## Lake House – Corrections Response Letter

Response to: 2012-200 Lorenzini Remodel 3R  
Dated: July 19, 2021  
Permit #: 2012-200  
Project address: 3310 97th Ave SE  
Mercer Island, WA 98040

**Re:** *Lorenzini Remodel (Lake House) at 3310 97th Ave SE Permit No. 2012-200*

1 MAIN FLOOR FRAMING PLAN
 1/4" = 1'-0"

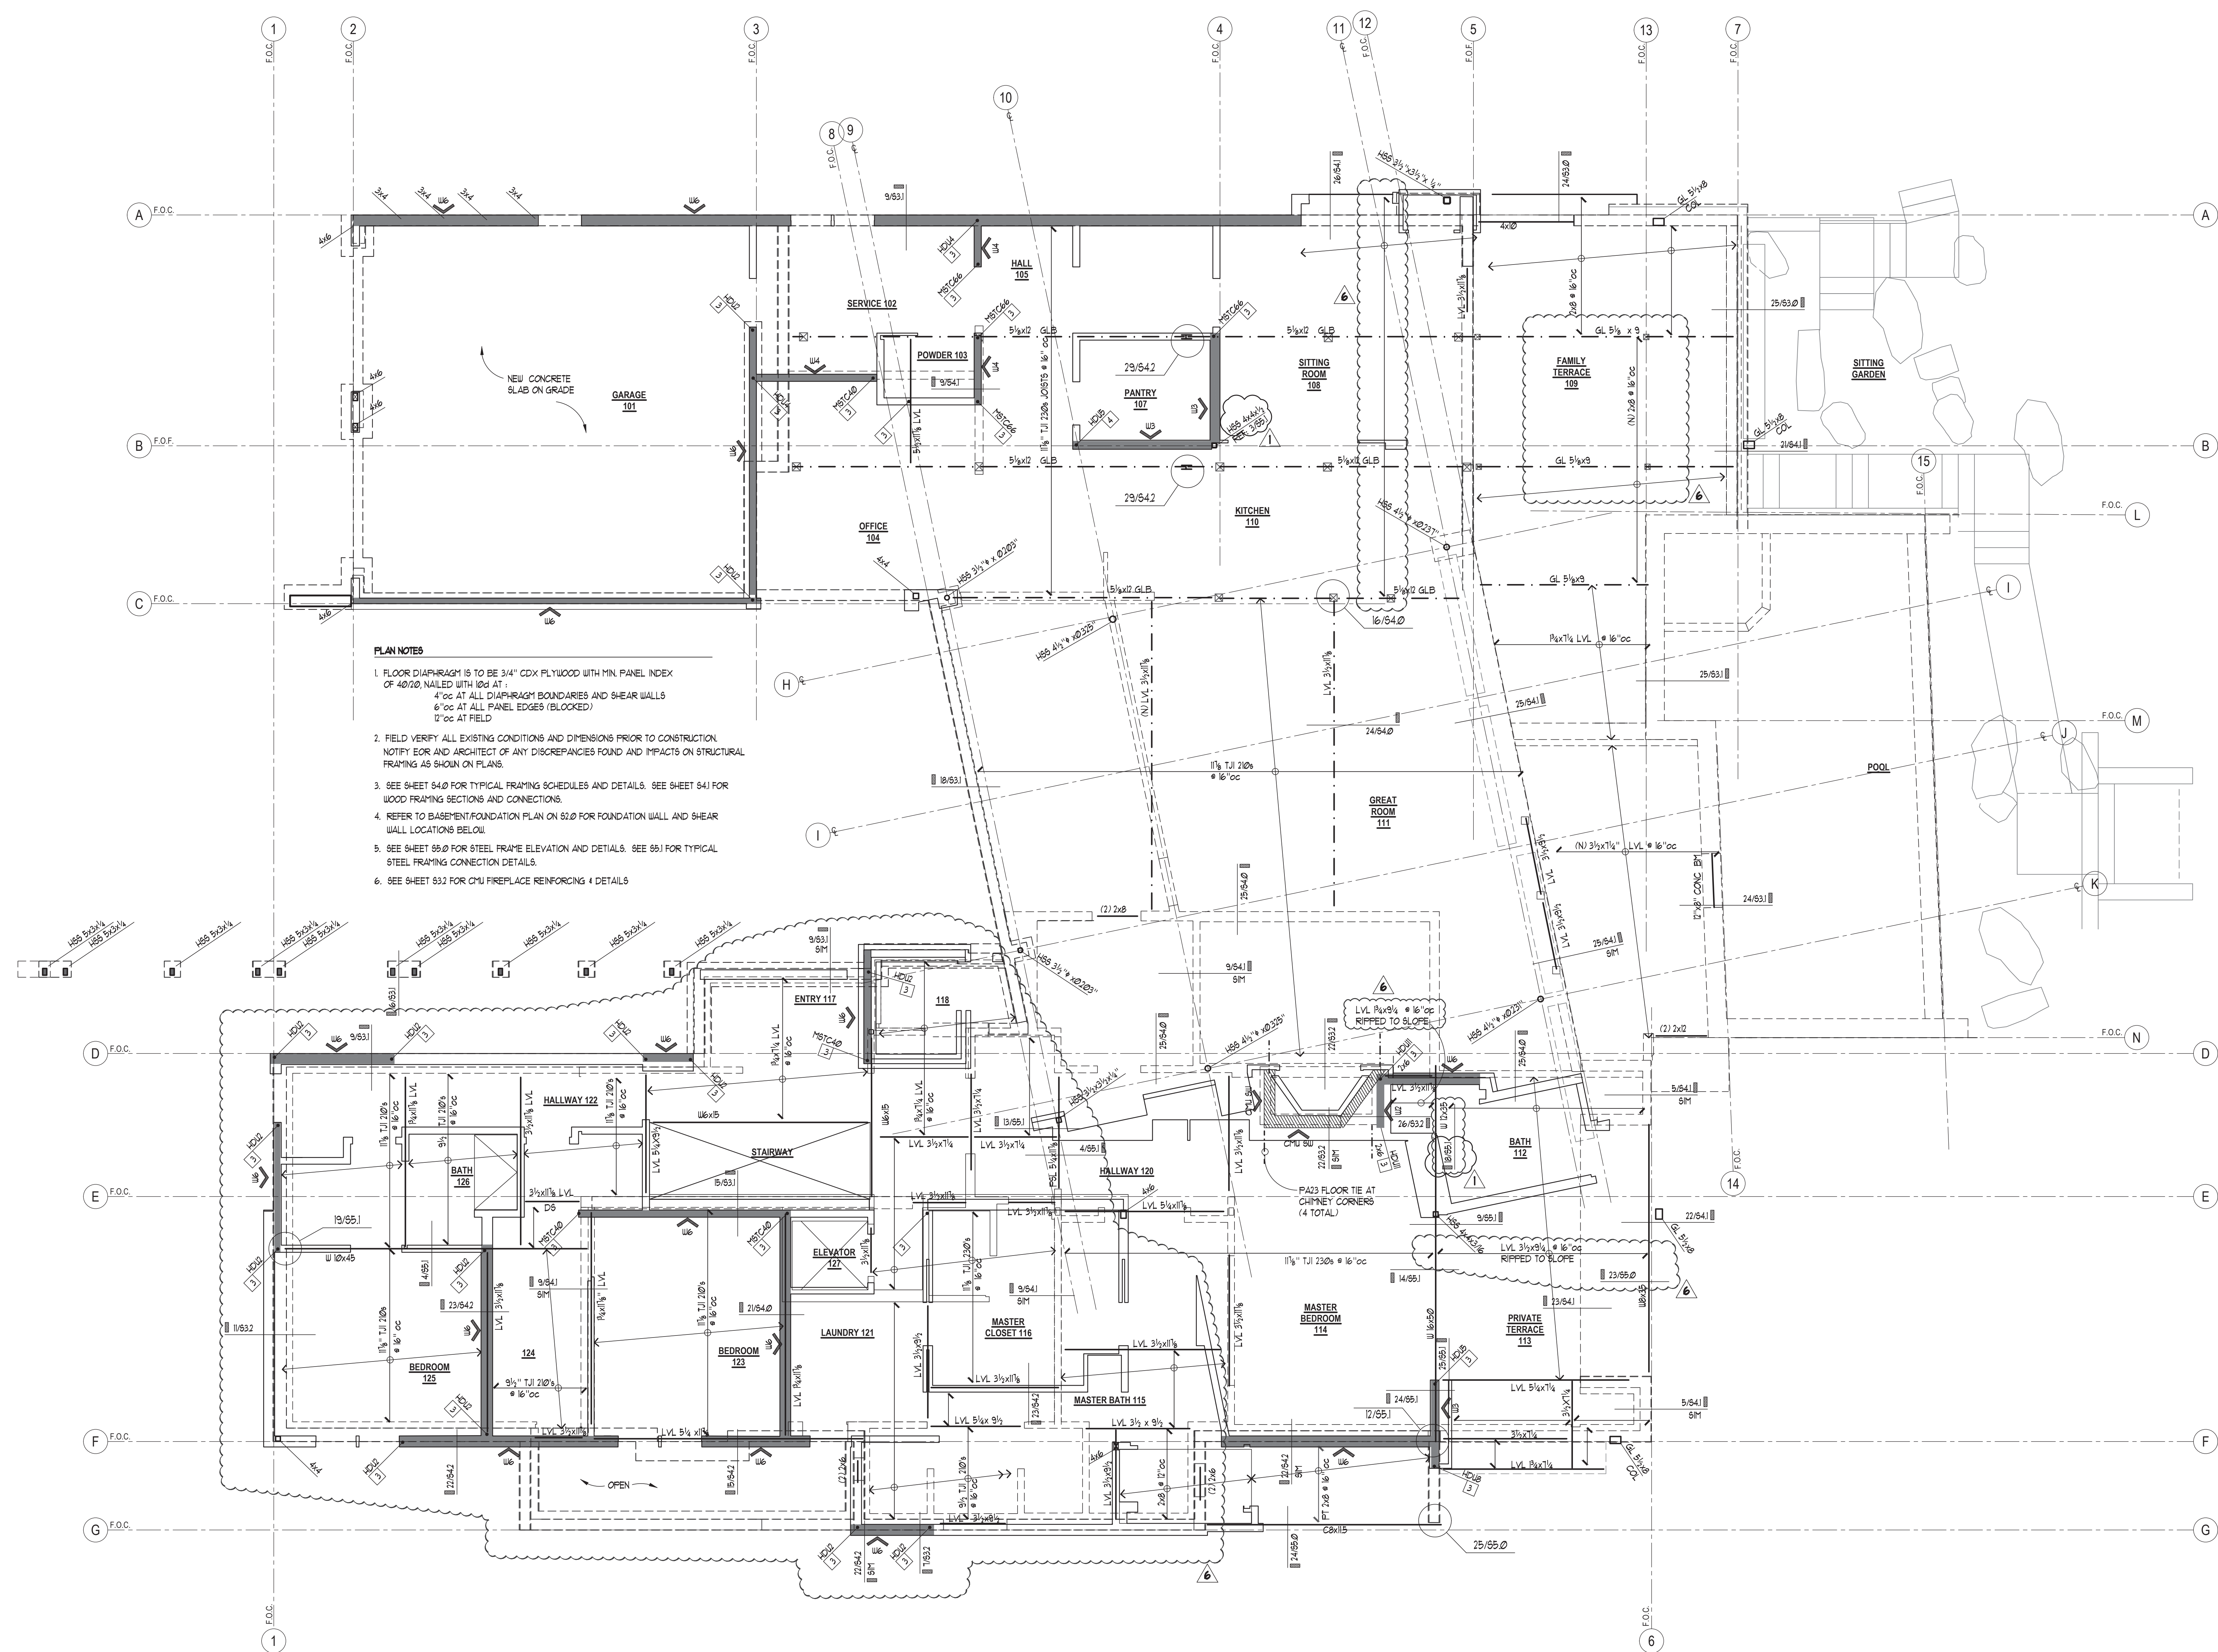
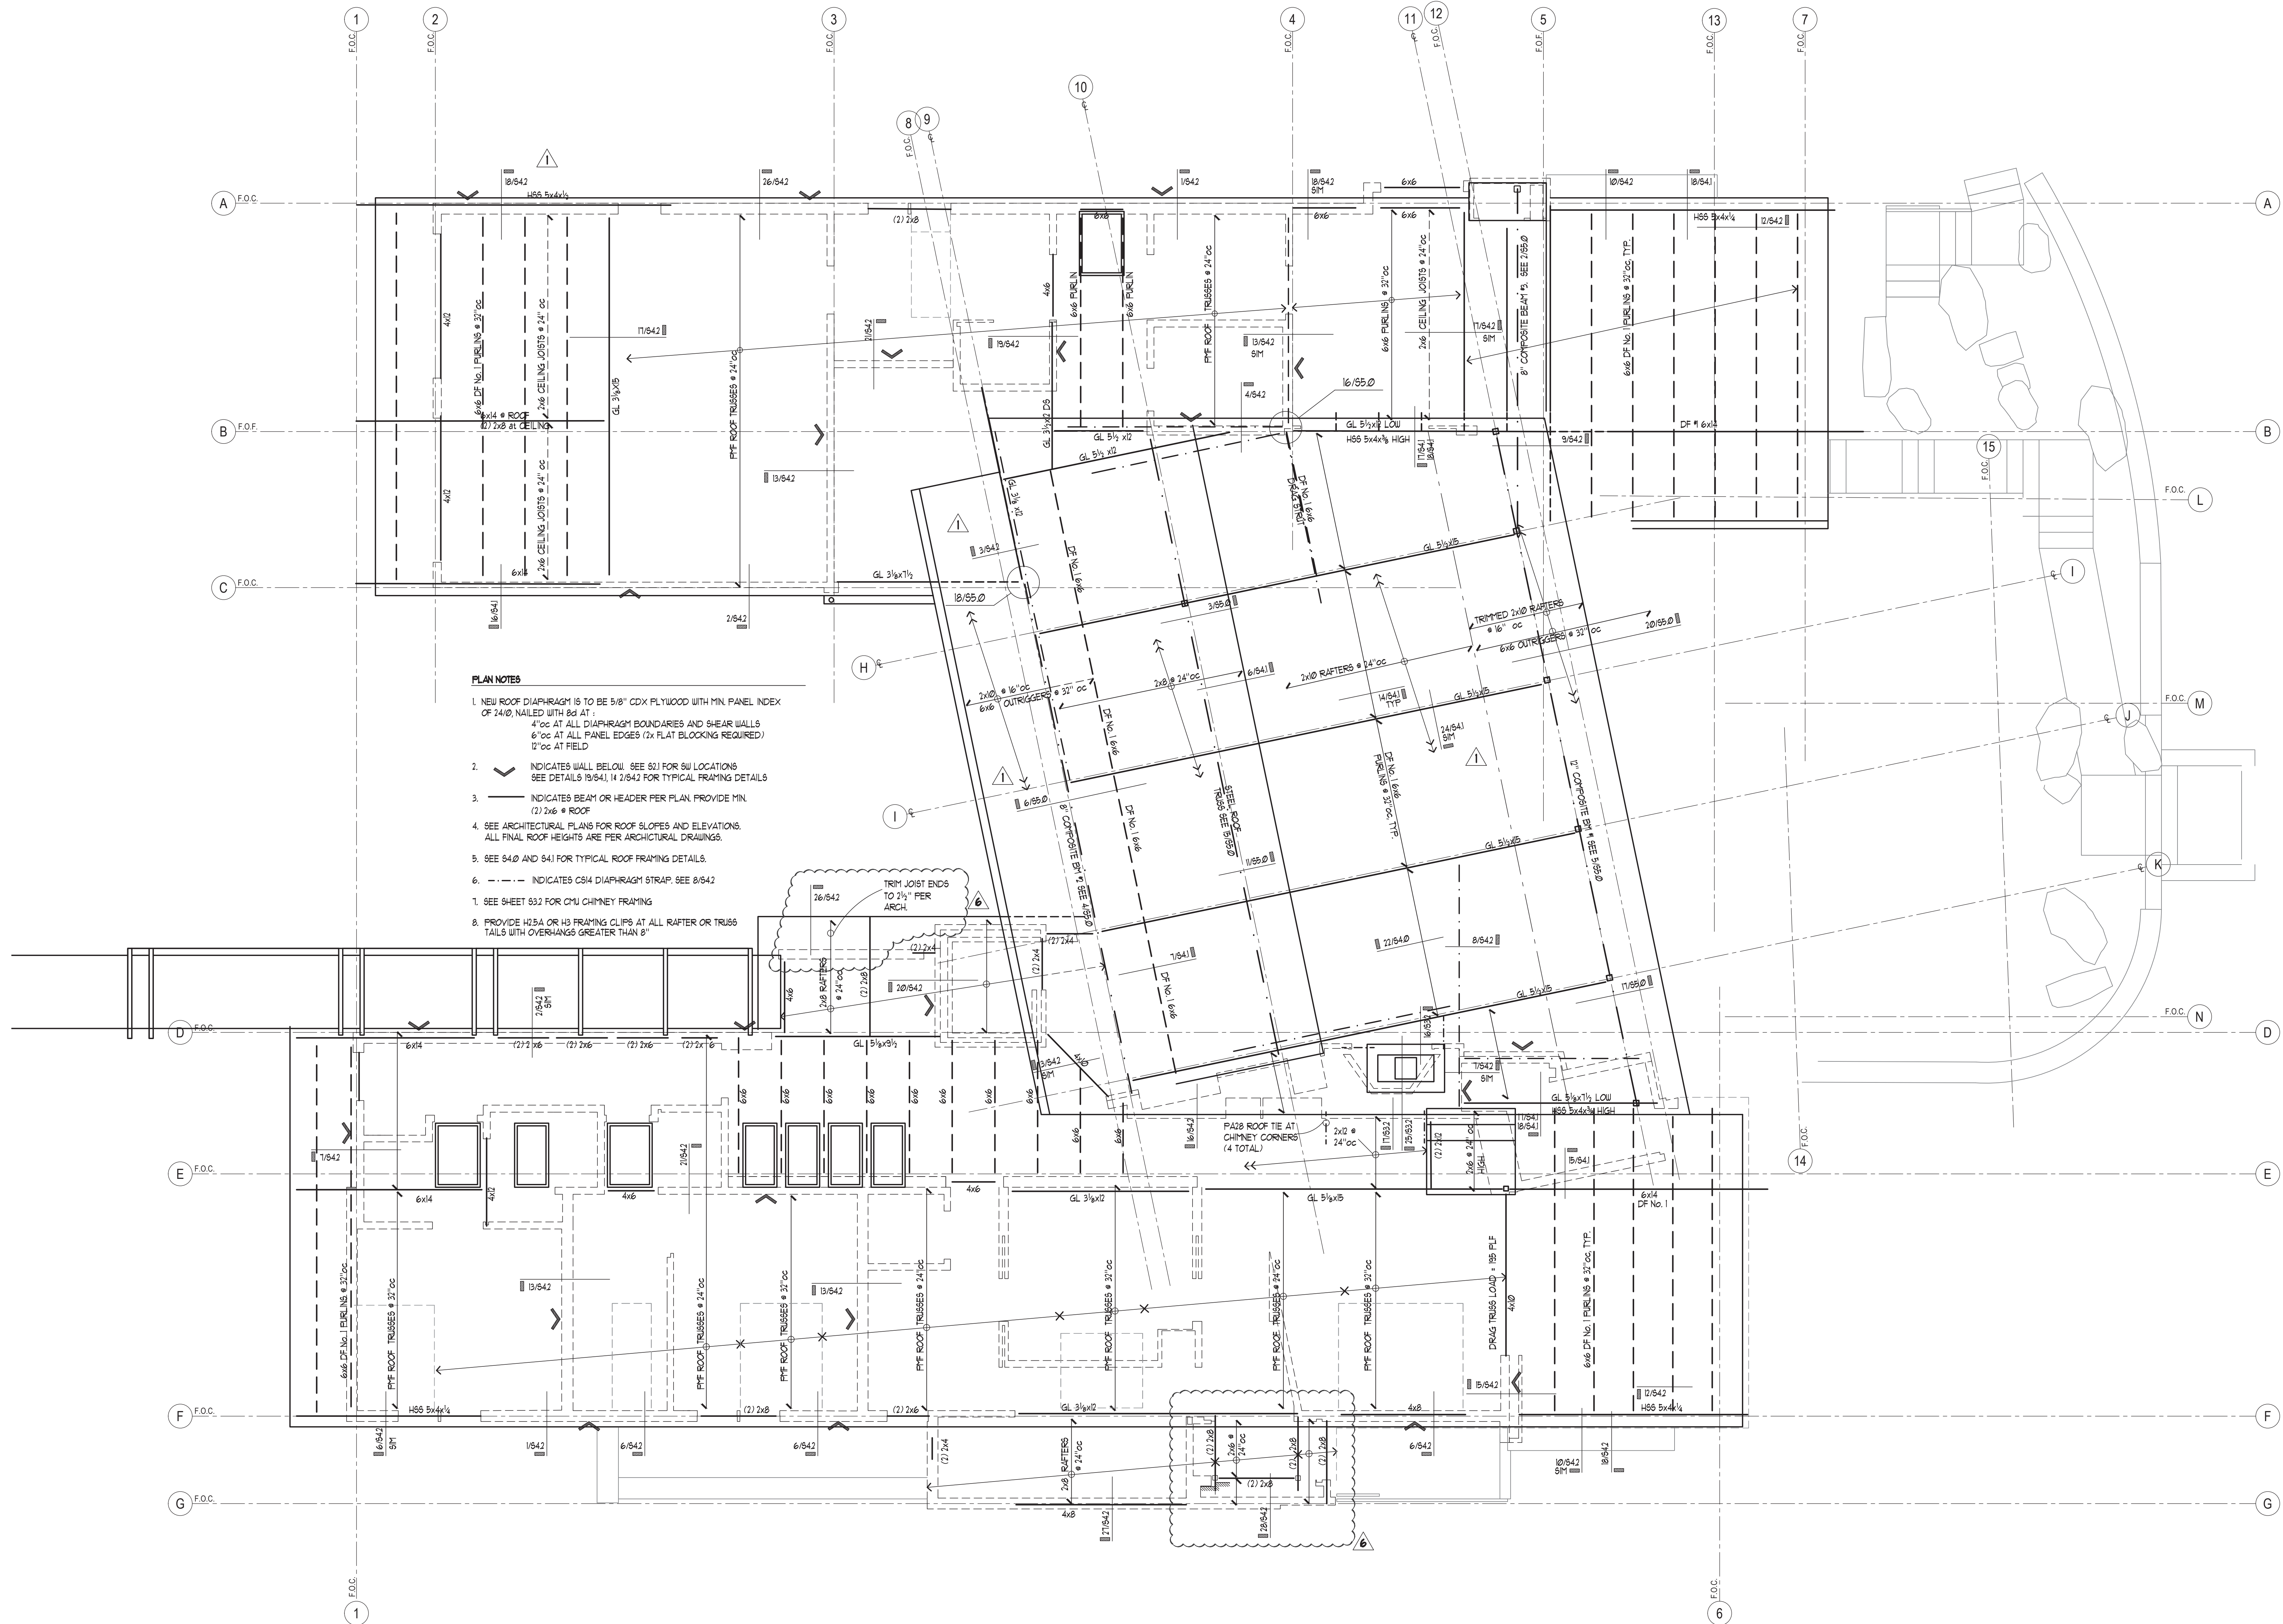
4. Cut a detail on the Main Floor Framing Plan, Sheet S2.1, showing shear flow

connection into the Type X & the west segment of the Type AA shear walls.

5. Due to the shear in the Type O shear wall, it appears a drag member will need to be provided on the Main Floor Framing Plan, Sheet S2.1. Please evaluate and detail.

6. The Type V shear wall has HDU11 holdowns into the top of the CMU wall at the fireplace as shown in plan on Sheet S2.1 and detailed in Detail 26/S3.2. The calculations show an uplift force of 15.9k, which exceeds the capacity of the HDU11 holdowns. Resolve discrepancy. Additionally, clarify post size to meet minimum size requirement per the Simpson Catalog.

Shear wall 'X' at Grid G lands on the existing concrete wall at the lower floor. Detail 22/S4.2 and 7/S3.2 have been cut at this location to clarify the framing.

Shear Wall 'AA' is located at grid 6 adjacent to the exercise room. Detail 5/S4.1 is already referenced at this location.

Shear Wall 'O' is designed for 2.73k of force delivered through the floor diaphragm over its 6' length, resulting in a load of 455plf. The floor diaphragm capacity is 680plf ( $850\text{plf} \times \phi=0.8$ ), so no additional collector beam is required. Detail 9/S4.1 is correctly cut at this location.

The uplift for Shear Wall V in the SW spreadsheet was being incorrectly calculating the overturning moment (due to how the height of the loads from the high and low roof elevations were entered), and has been corrected on the attached spreadsheet. Also, the HDU11 holdown capacity for the LRFD shear wall loads has been increased above the ASD capacity published by Simpson to account for the different load and duration values used.

The stud packs at the ends of SW-V have been clarified to be 2x6 studs to meet the requirements for the HDU11
